RE: Drainage Complaint for 440 Narcissus Place SE (L23-D1C))

RE: Drainage Complaint for 440 Narcissus Place SE (L23-D1C))

RE: Drainage Complaint for 440 Narcissus Place SE (L23-D1C))

RE: Grading Plan for 440 Narcissus Place SE (L23-D1C)) Dated January 30, 2002

440 NARCISSUS PLACE S.E.

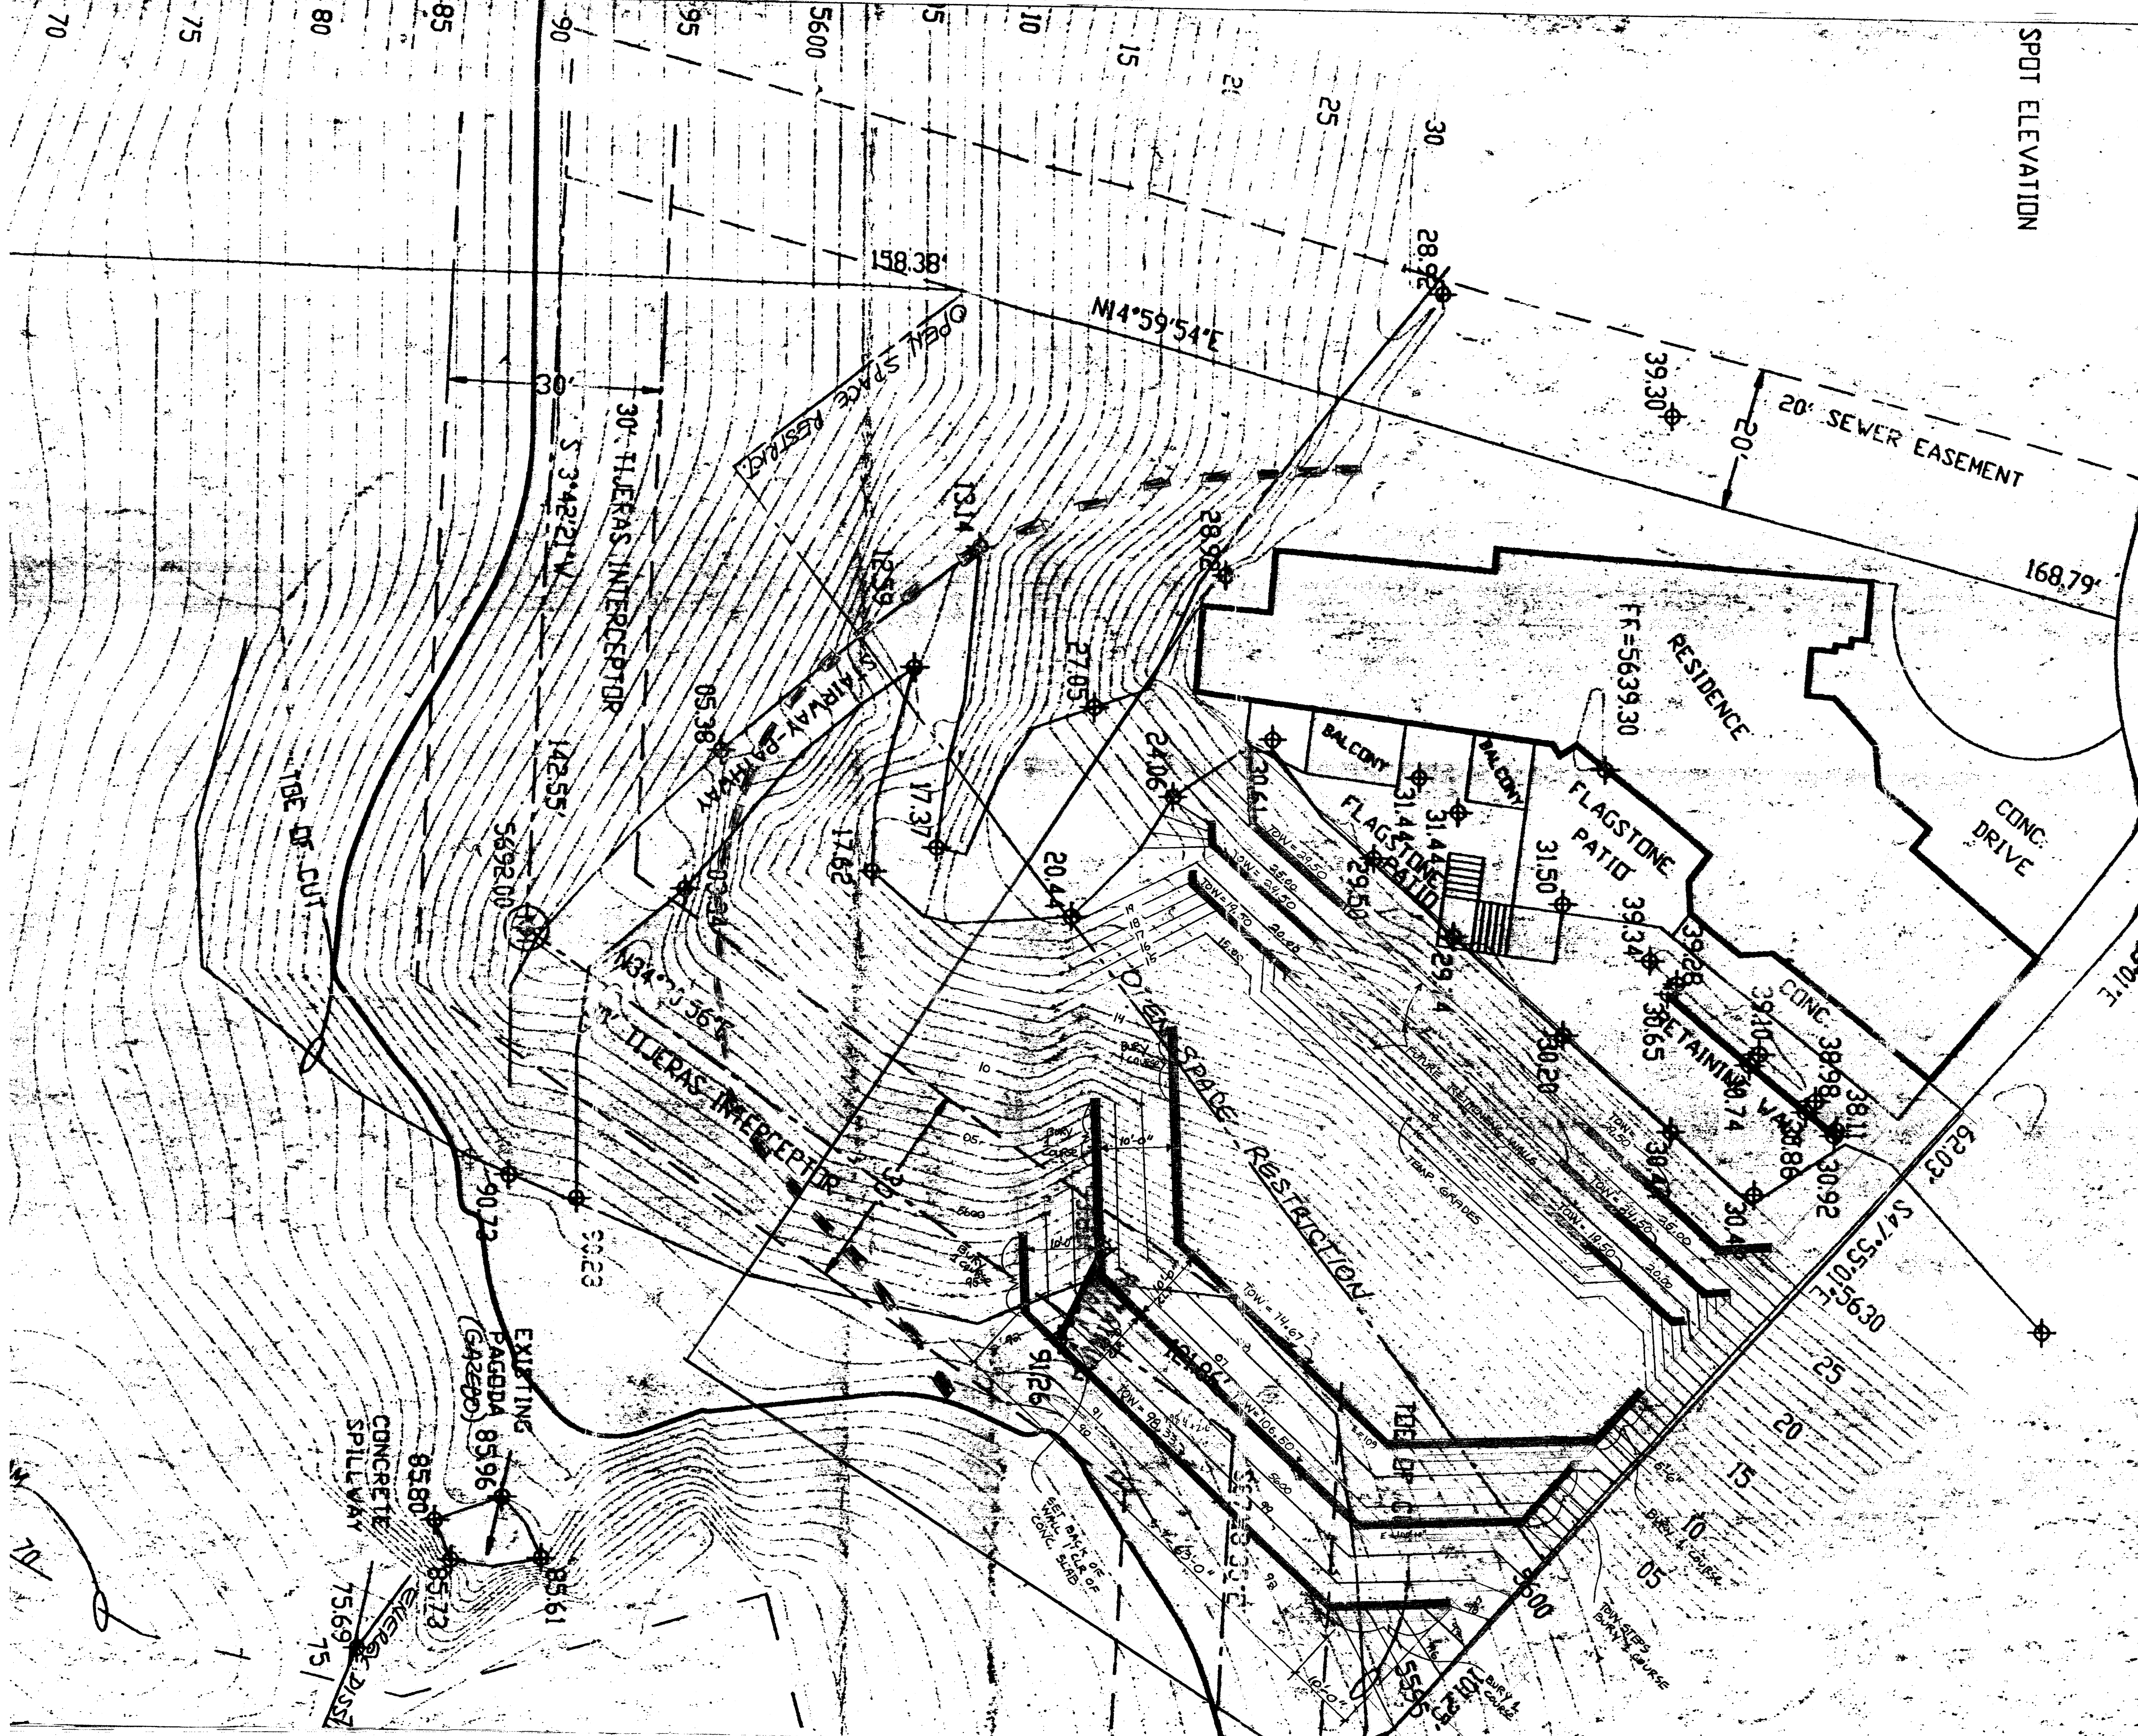
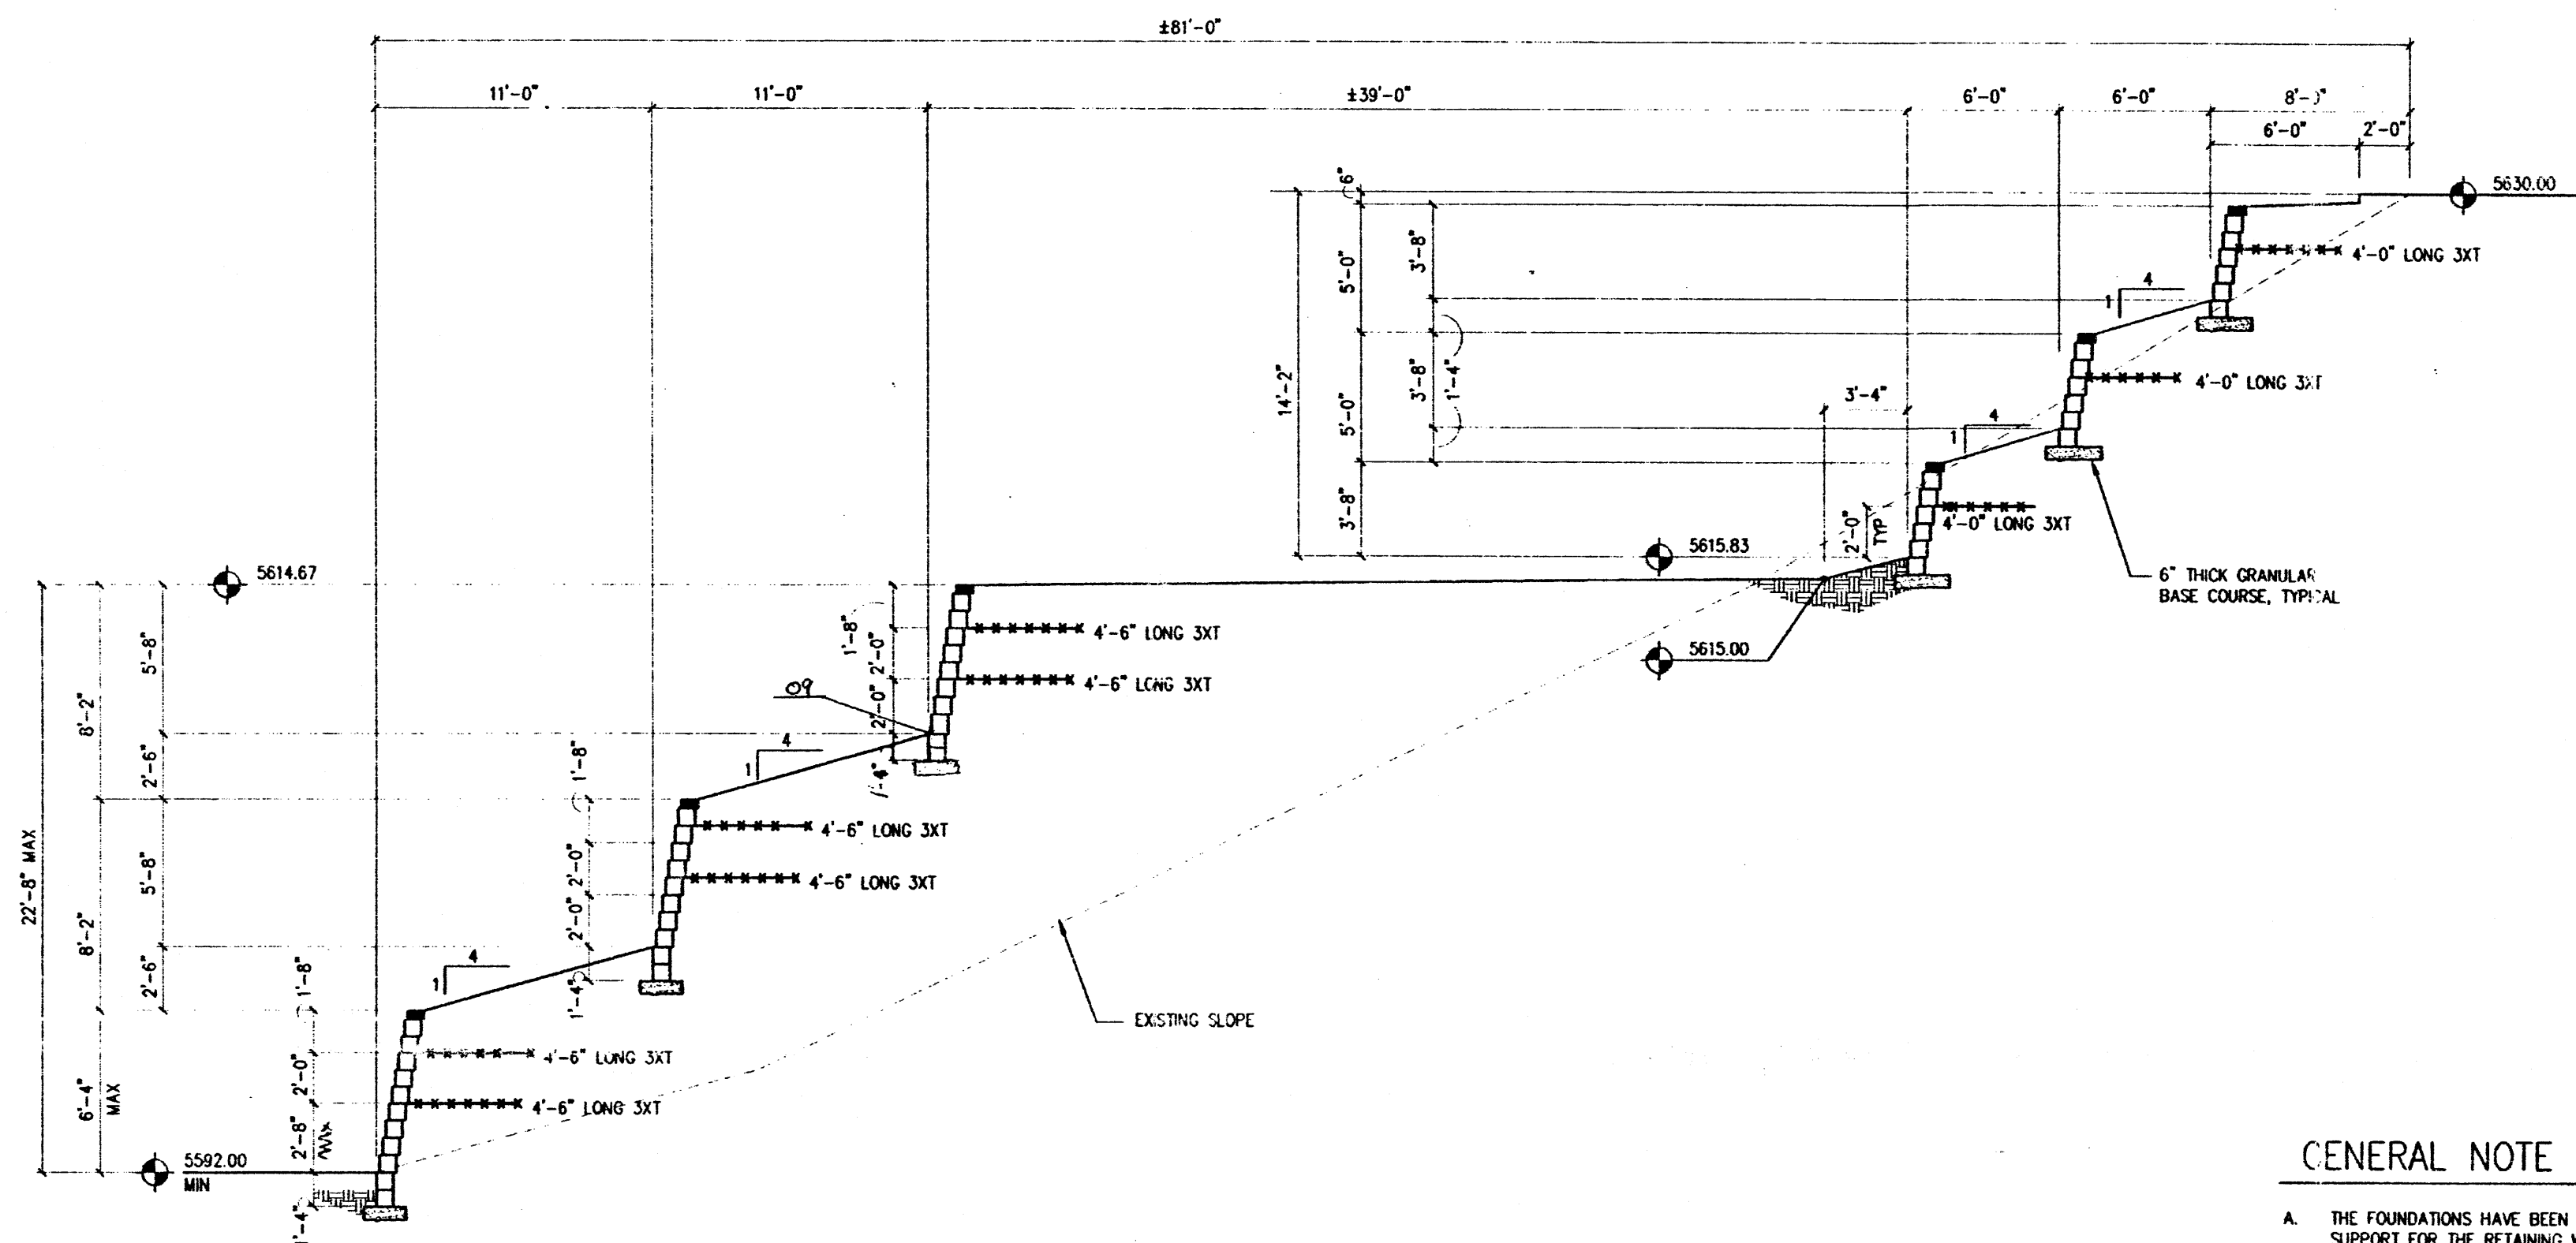
- 2. It appears that you are grading and building the retaining wall outside of your lot of 440 Narcissus Place. Please submit a legal description for the lot you are making improvements on. Is Masha the owner of this lot? Please show on the drawing the deeded lot.

- 3. The grading and retaining wall is being placed on is on a deeded lot. The drawing indicates that this is an open space area that has restrictions. Please submit the latest plat for this area. Are there any restrictions on grading and the construction of retaining walls?

- 4. I spoke with the Planning Department on the SU-1 zoning. They indicated that there was not a problem with what you were doing as far as zoning.
- 5. The grading plan uses a sanitary sewer manhole as a benchmark. Please indicate if this is an accurate benchmark and has been checked.

The above referenced grading plan is approved for grading in the "work area" as designated on your plan. The Encroachment Agreement is approved and has been sent to your address. Please obtain a retaining wall permit for your proposed retaining walls.
